**PLANNING APPLICATION NO. N6/2010/2055/MA**  
**PLANNING APPLICATION NO. N6/2010/2060/LB**  
**BROADWATER ROAD WEST REGENERATION – TESCO/SPENHILL**

I object to the Tesco (Spenhill) proposals on the following grounds:-

02. BRIDGE LEVEL PLAN : PROPOSED

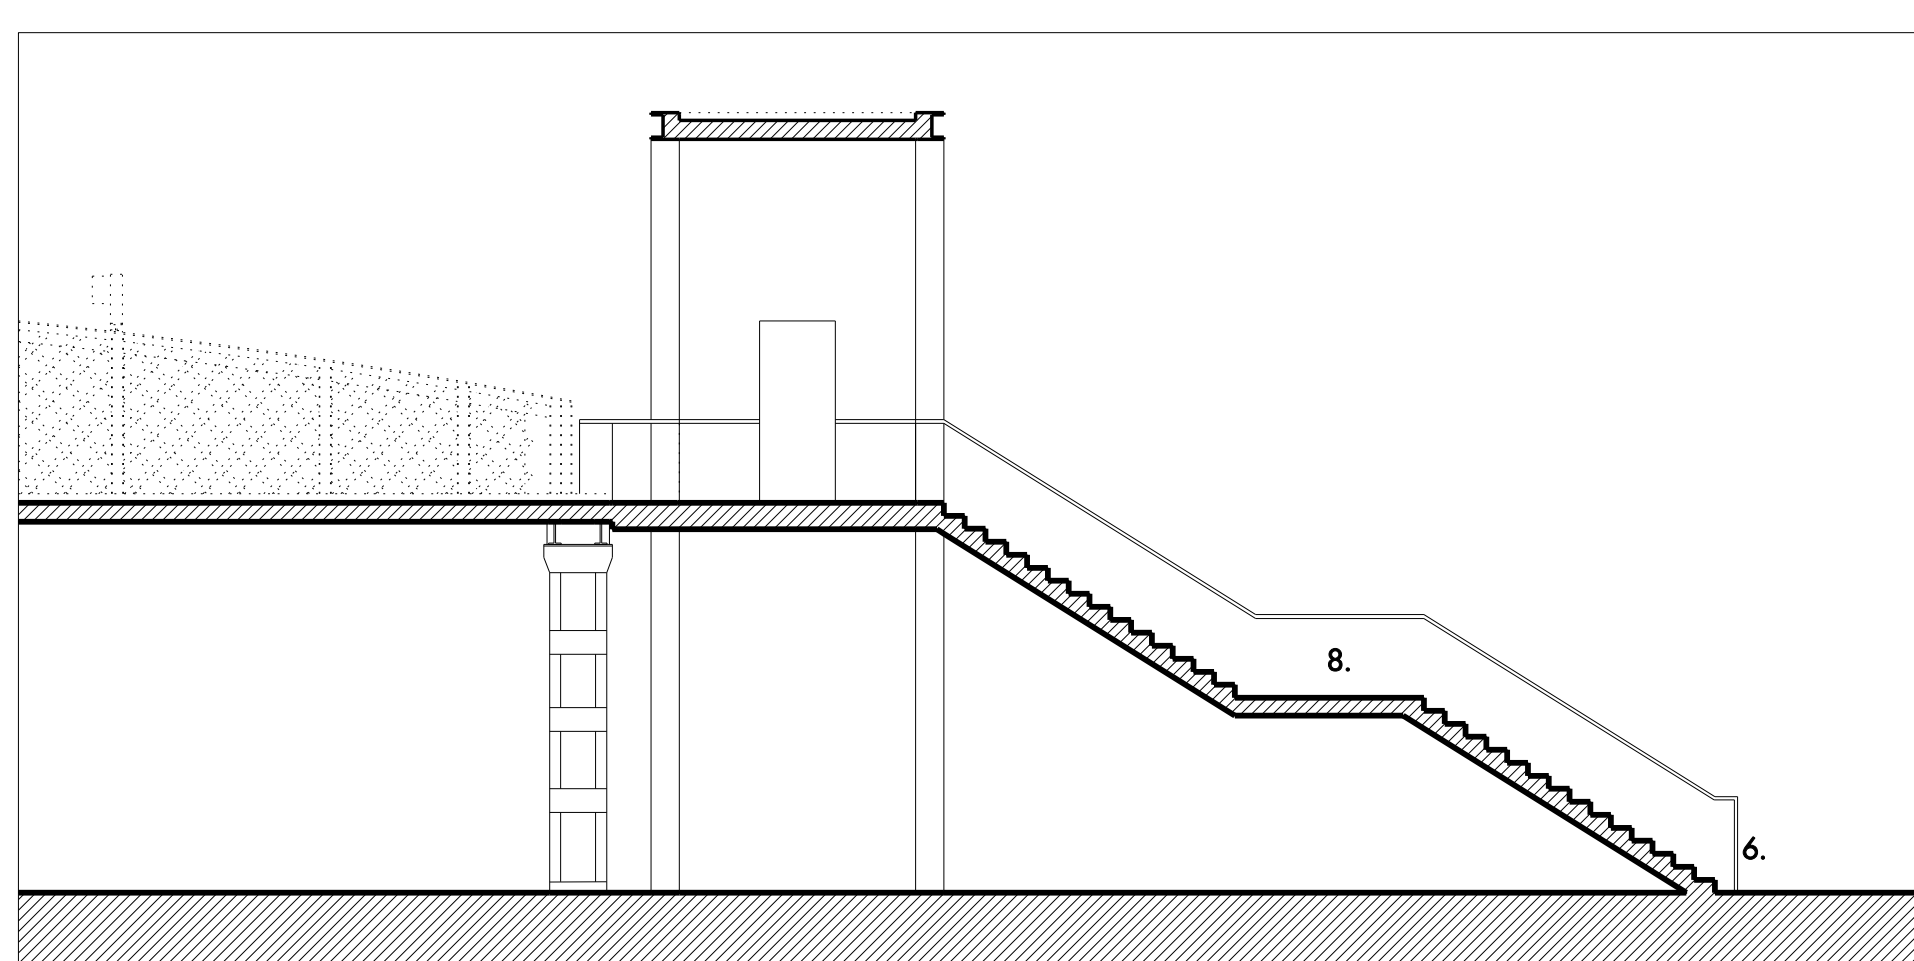
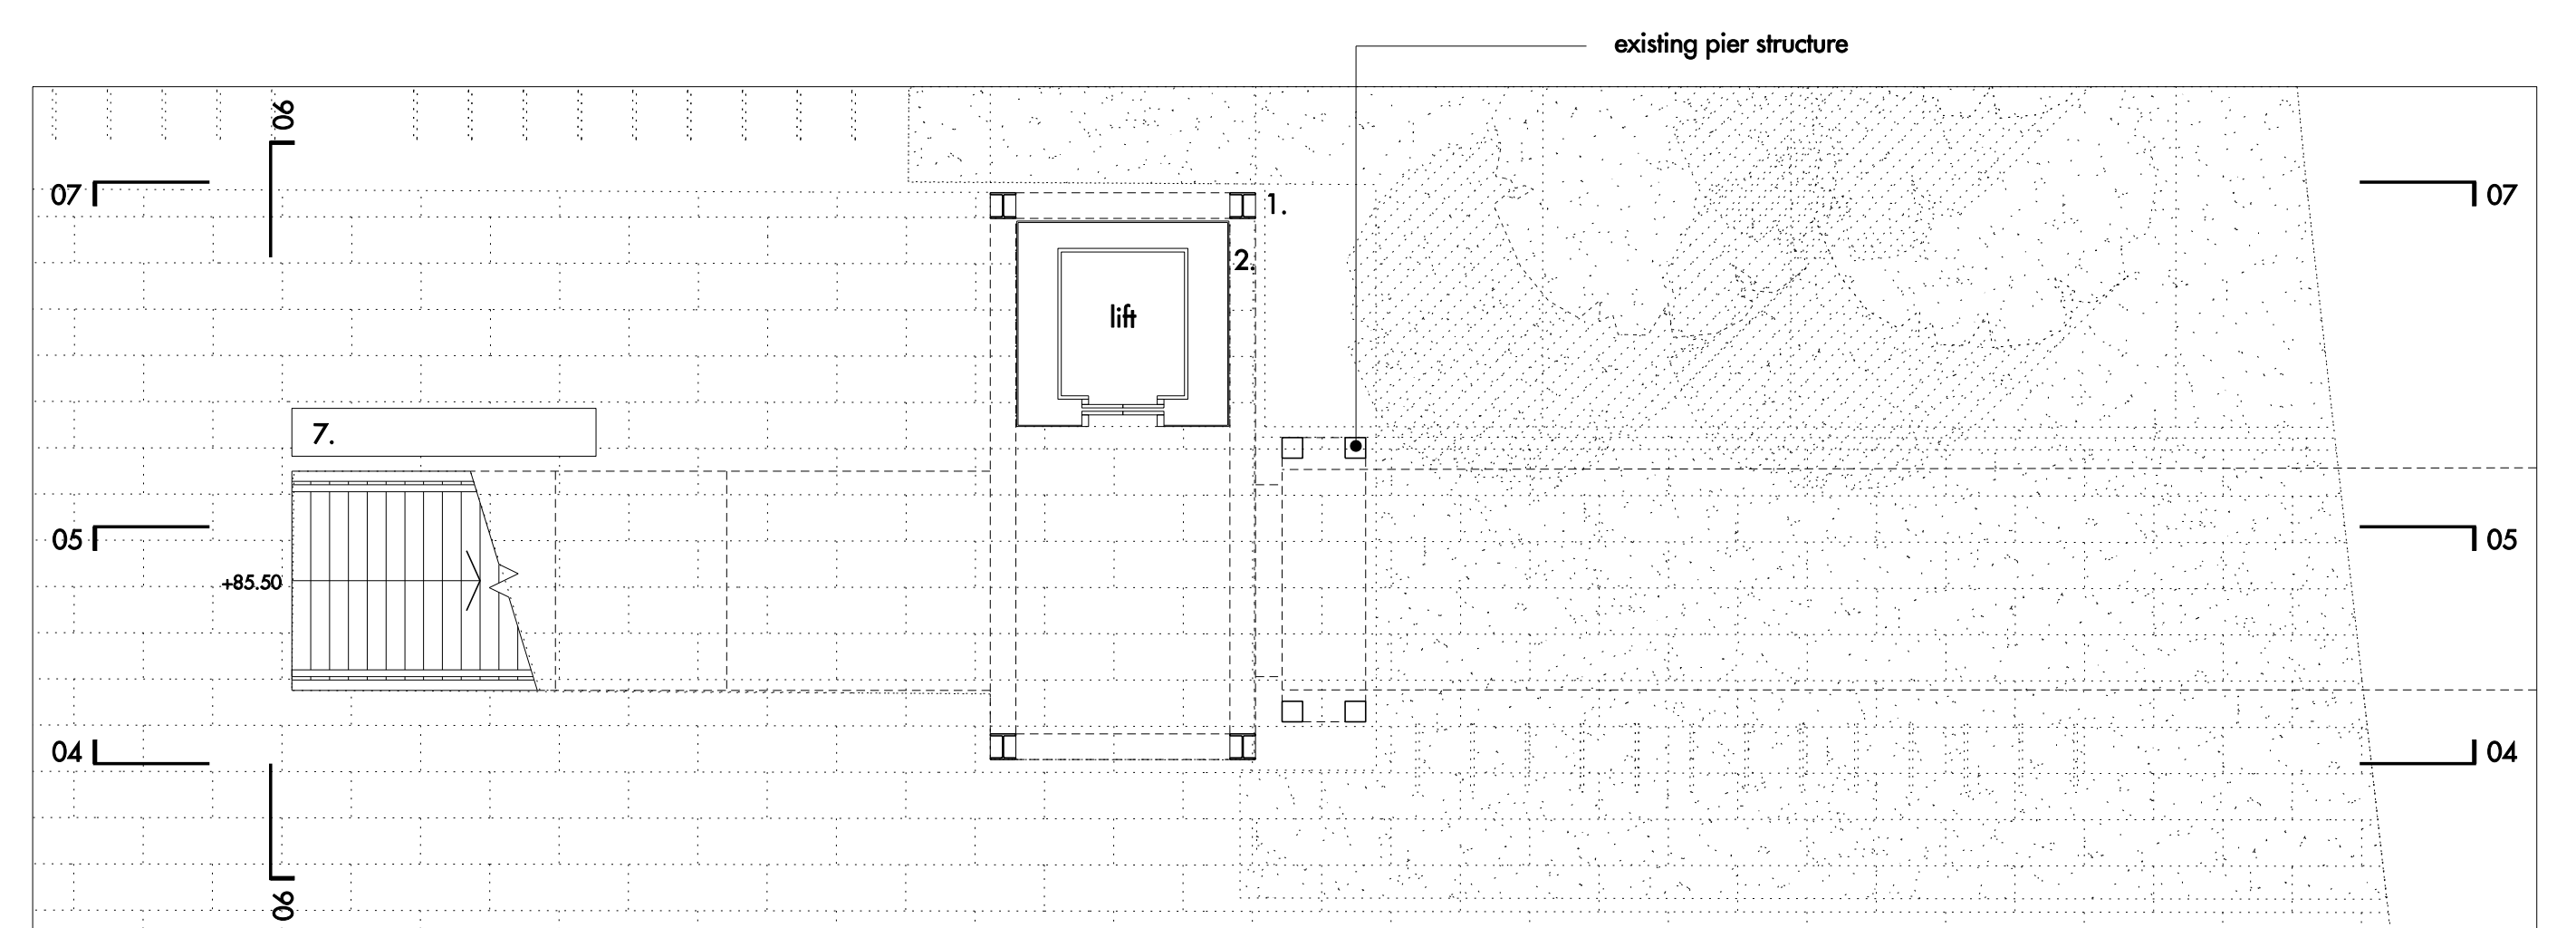
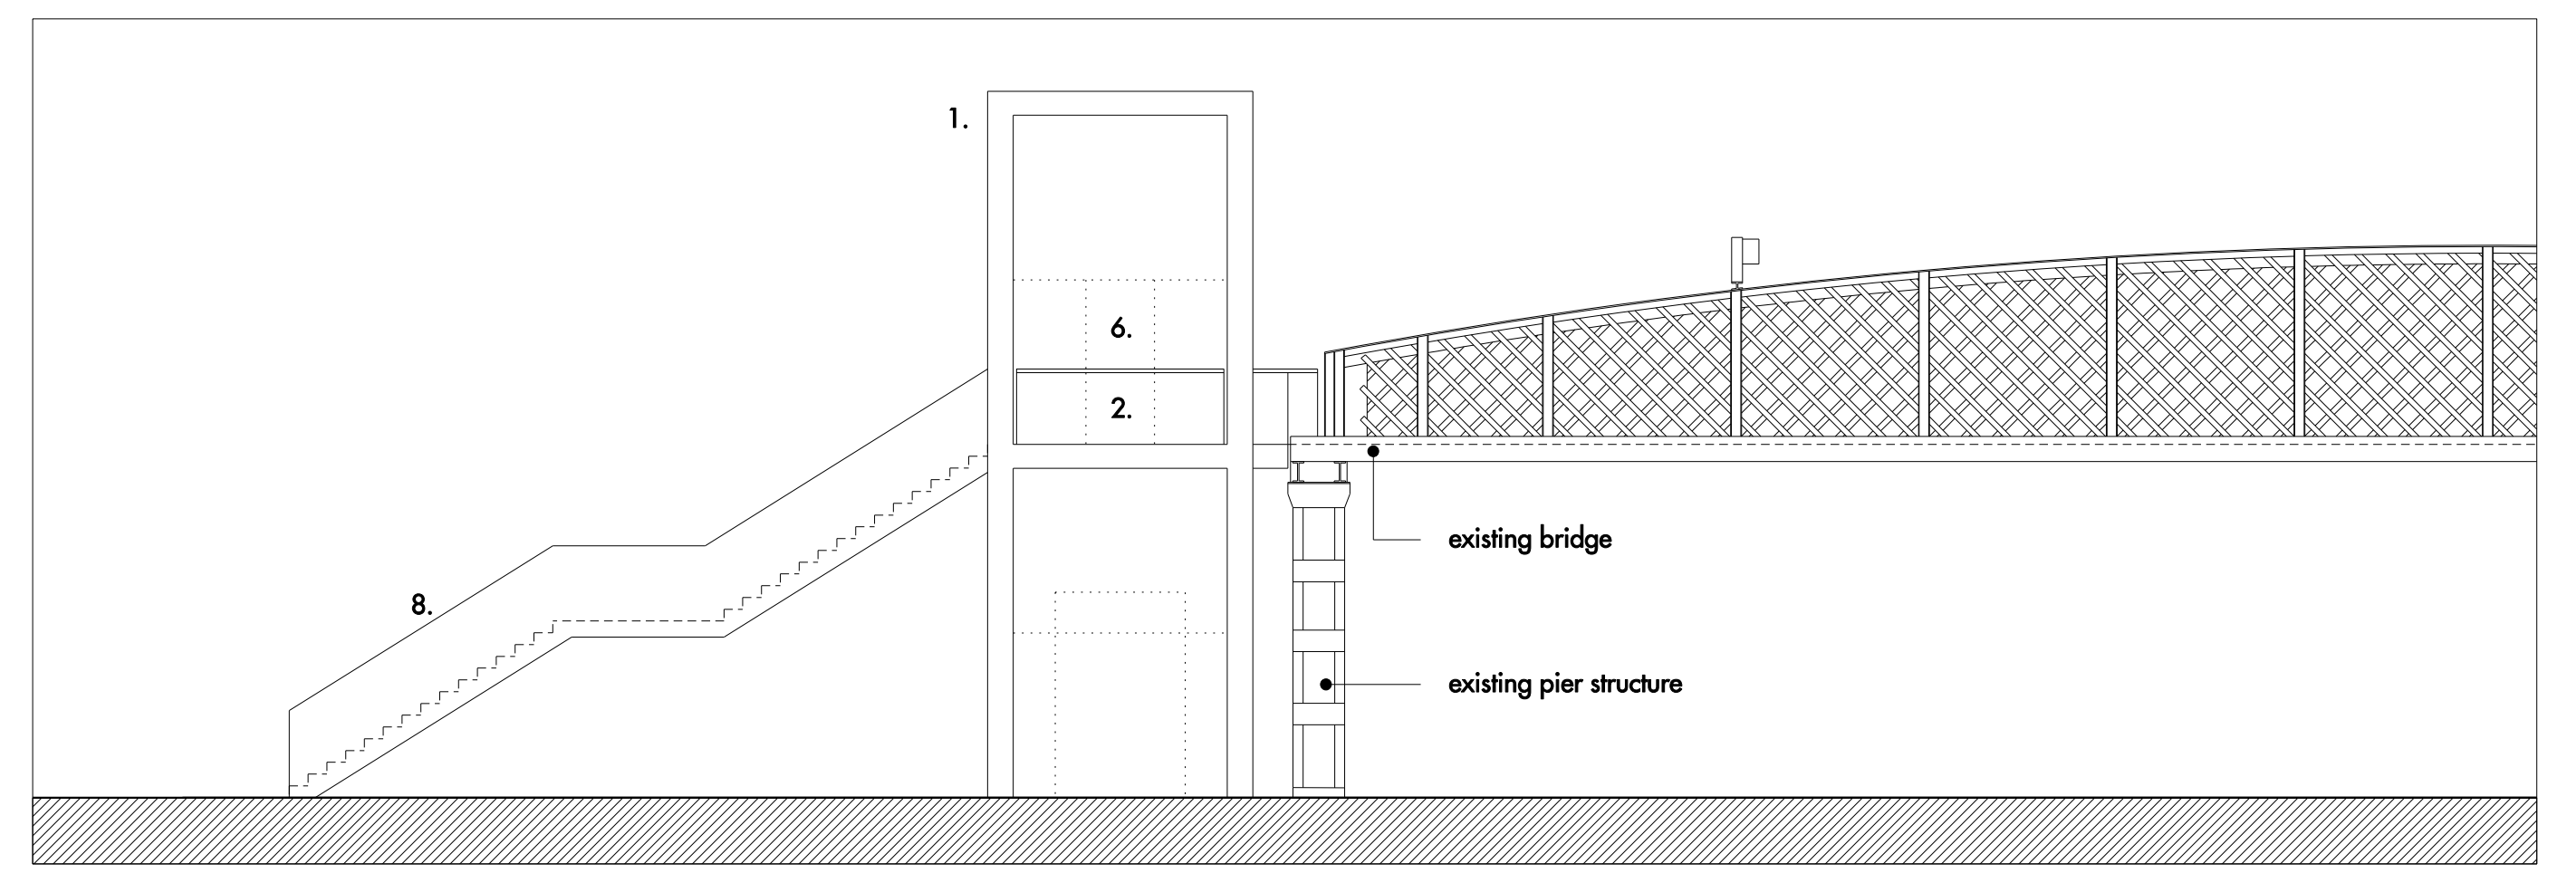
13. The pedestrian bridge over the railway is shortened and has a (too) small lift but otherwise remains the same. The narrow width therefore will not be able to accommodate the additional pedestrian traffic necessary to demonstrate satisfactory integration with the existing town centre. It will be a significant constriction to flow.
